DEVELOPMENT REVIEW BOARD
SUPPLEMENTAL SUBMITTAL

PROJECT NO. 2020-003461 (17EPC-40043)
Application No. SI-2020-00052

SUBMITTAL DESCRIPTION: Revised plans, Approved Fire One, and response to comments

RE: Project #2020-003461/SI-2020-00052 (17EPC-40043), Taylor Ranch Housing
Site Plan-EPC Major Amendment

SHEET #
C2
 JOB #
 2019080

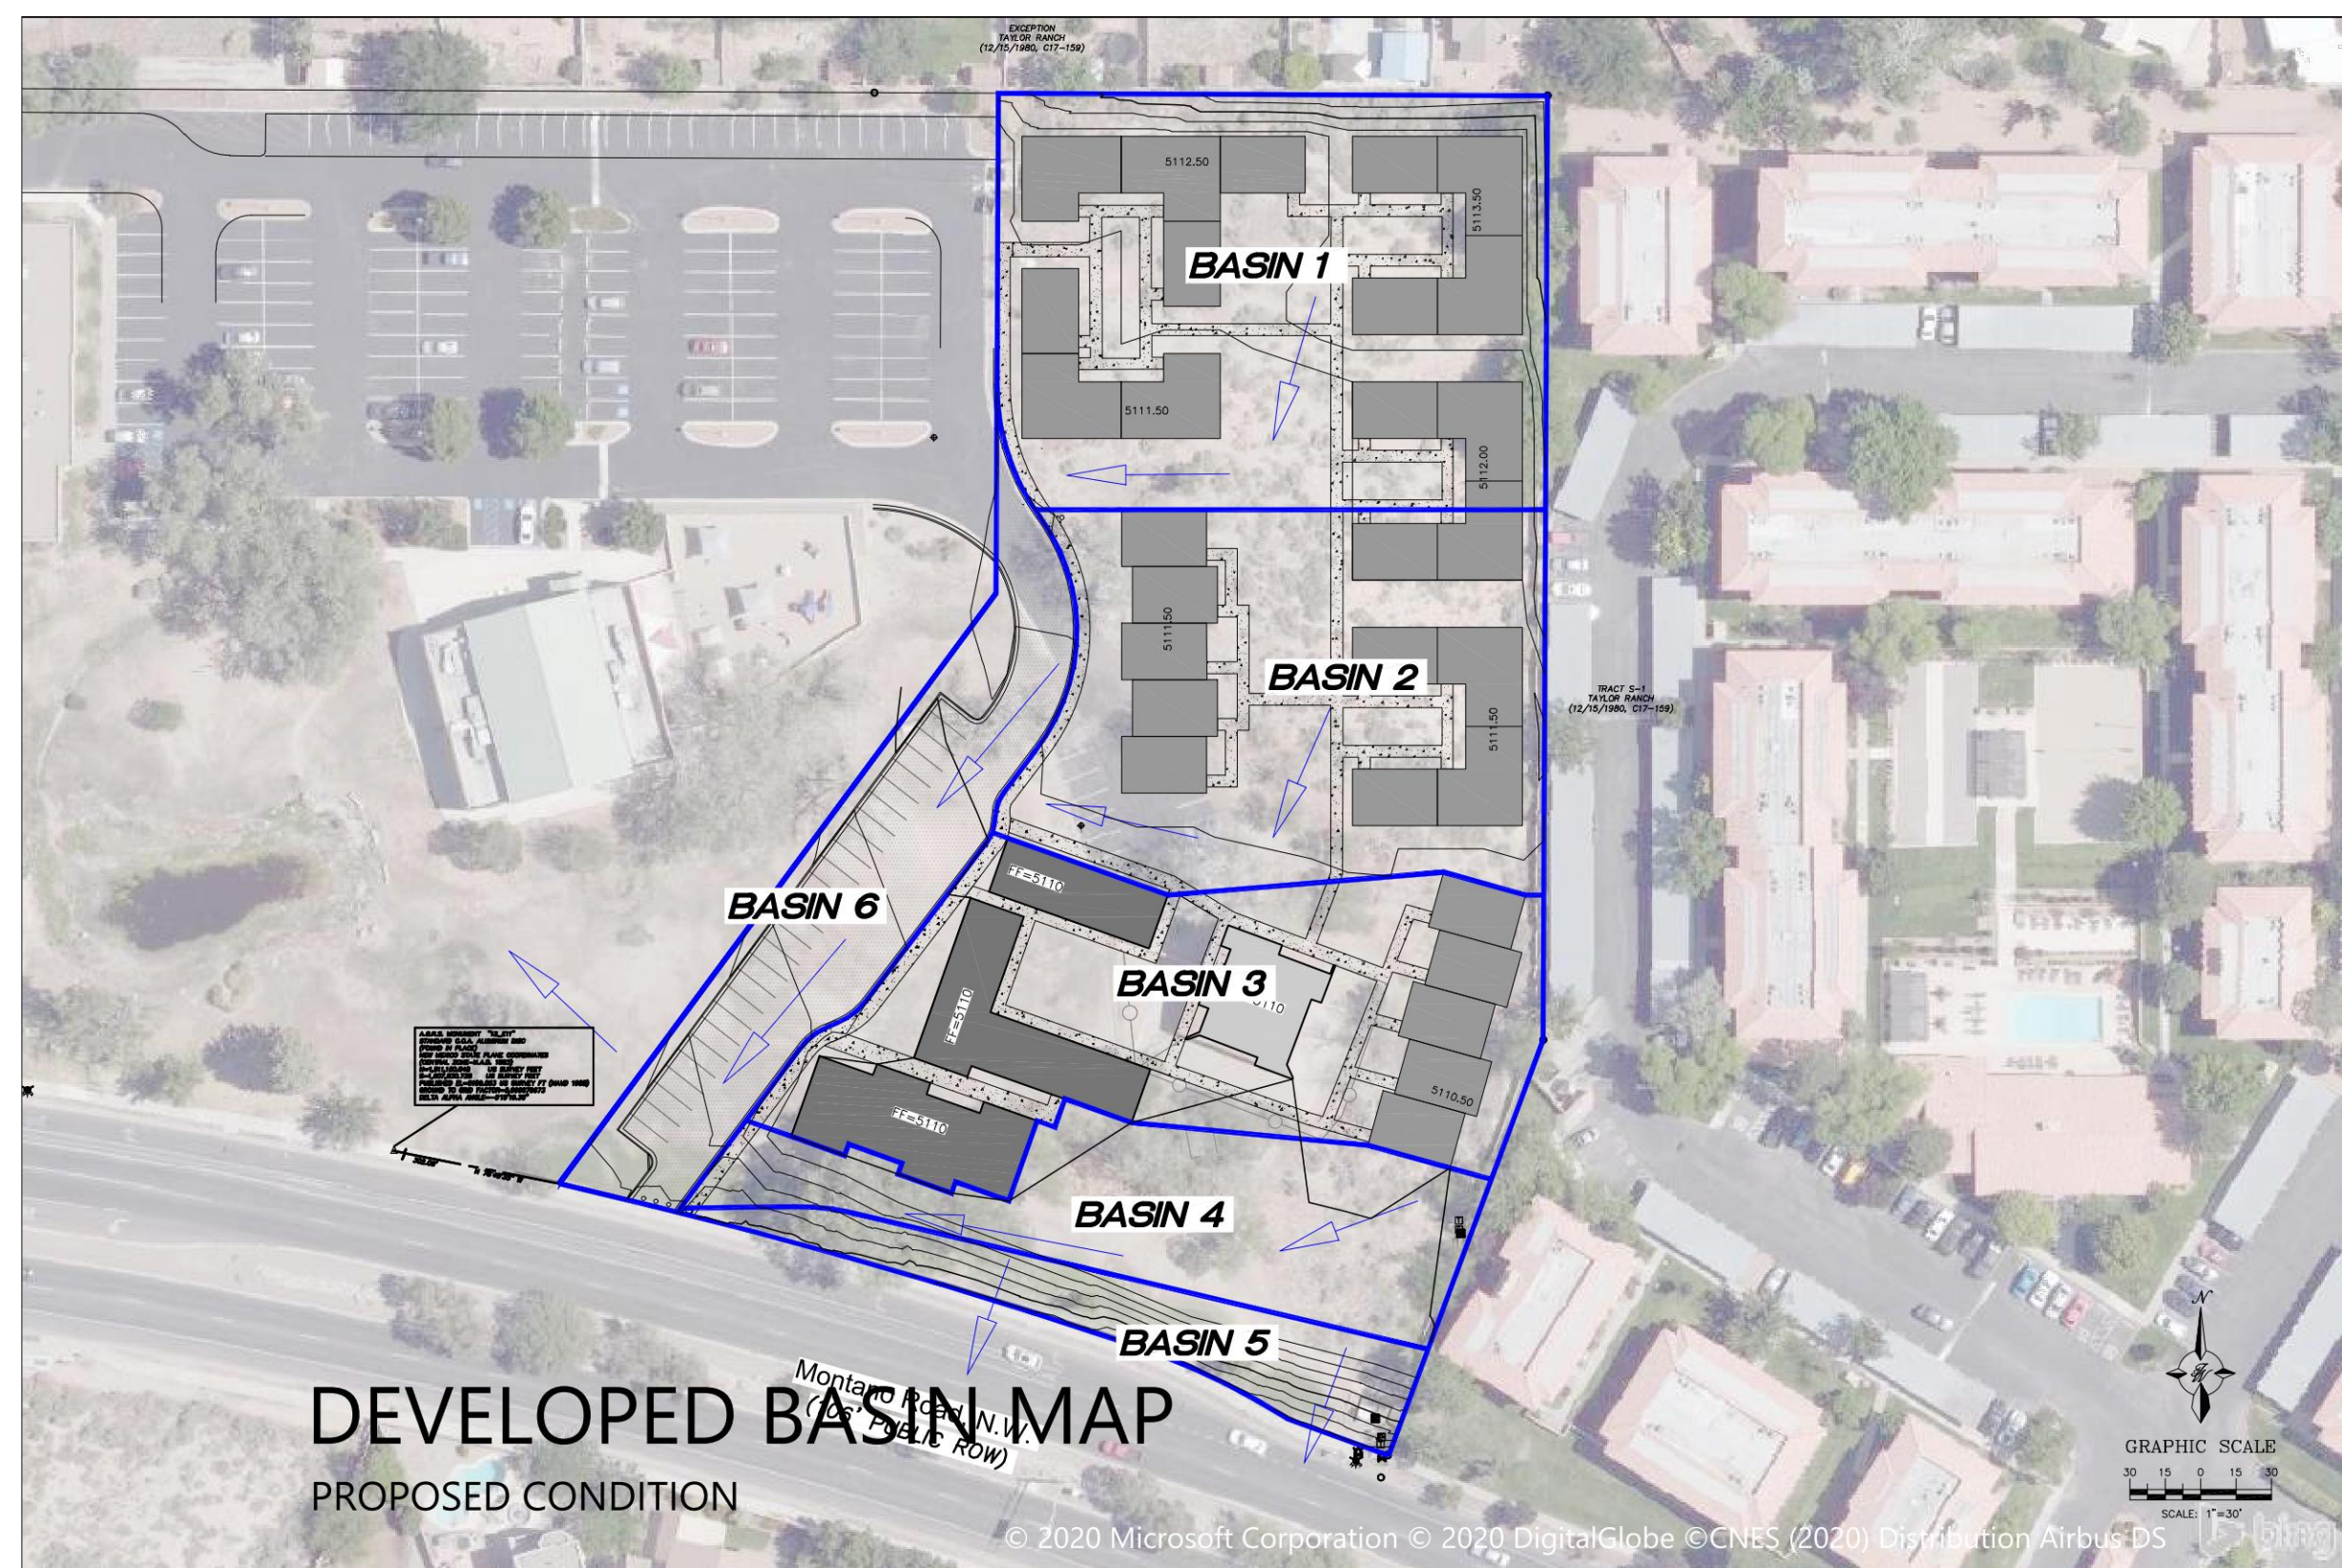
6. Condition 7A- unmet: Curb notches shall be labeled and match locations on the grading and drainage plan(s).

7. Condition 7B- unmet: A curb notch detail shall be provided.

11. Condition 11- unmet: Grading and Drainage Plan: Curb notches shall be shown in the same locations as on the landscaping plan.

Response: Area inlet is labelled on the site plan/grading plans.

Response: Area inlet detailed on grading plan C-2 callout.

SARANAM AT	DRAWN BY
	4701 MONTANO RD NW	BF
	CONSTRUCTION DETAILS	DATE
		7/28/2020
		2019080_DTE
		SHEET #
		C4
		JOB #
		2019080

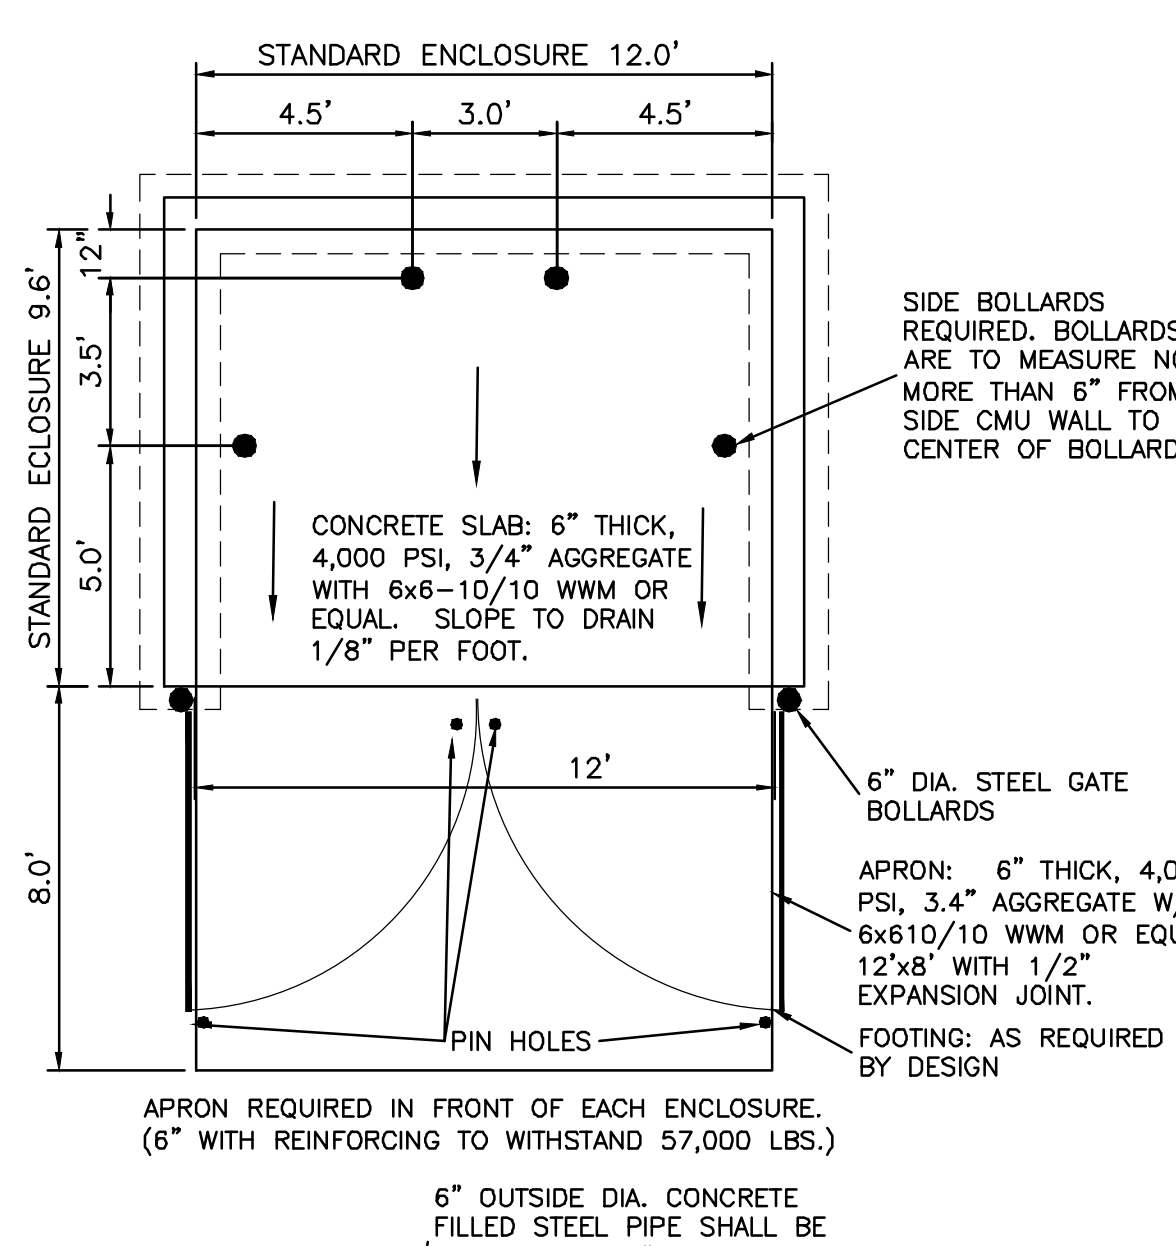
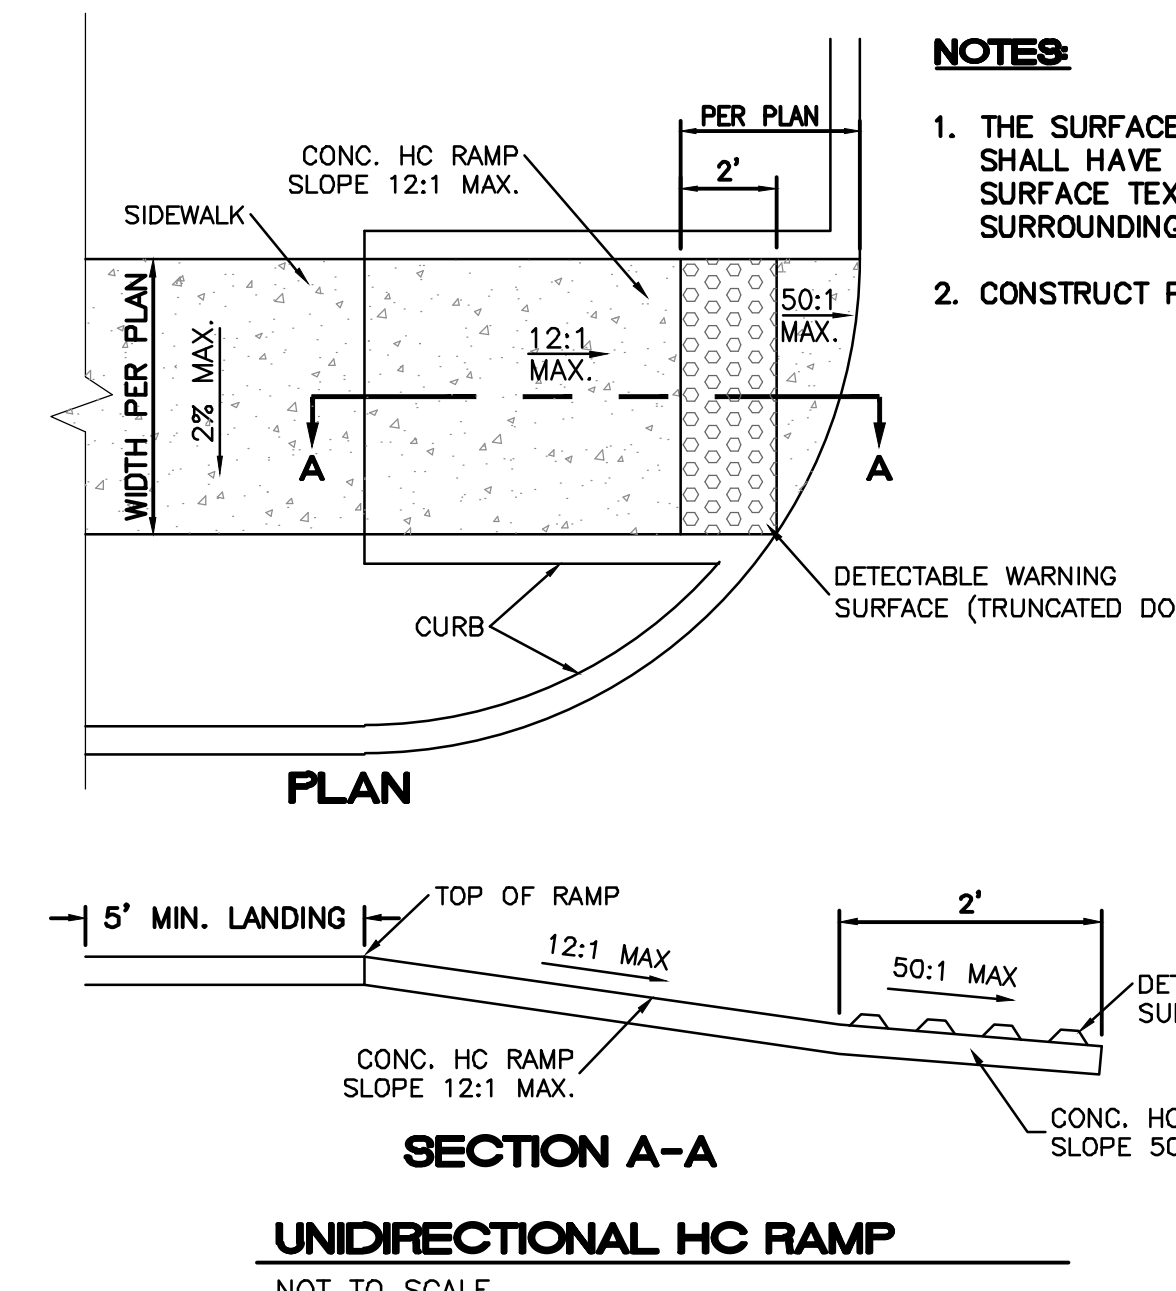
9. Condition 8C- unmet in part: The refuse enclosure detail does not specify color(s).

1. A fence was added to the main site plan (Sheet C-1) near the southern portion of the subject site (keyed note 23).
2. A detail of the unauthorized fence was added to Sheet C-4.
3. The height of the new wall on the subject site's northern side was changed from 2 to 3 feet.
4. The crosswalk detail was removed from Sheet C-4 and must be re-instated and comply with IDO 14-16-5-3-(D)(3)(c).
It was relocated, still on C-4 to the right side of the page.
5. The second sheet of the landscaping plan was removed and needs to be put back.
6. Building perspective Sheet B-1 was added, and should be removed, since the EPC didn't see or approve it and it was not a condition.
7. The northern landscape boundary was changed to a monoculture of Bosnian Pine, which is not what the EPC approved and was not in a condition.
- 8.

Response: Color reference added.
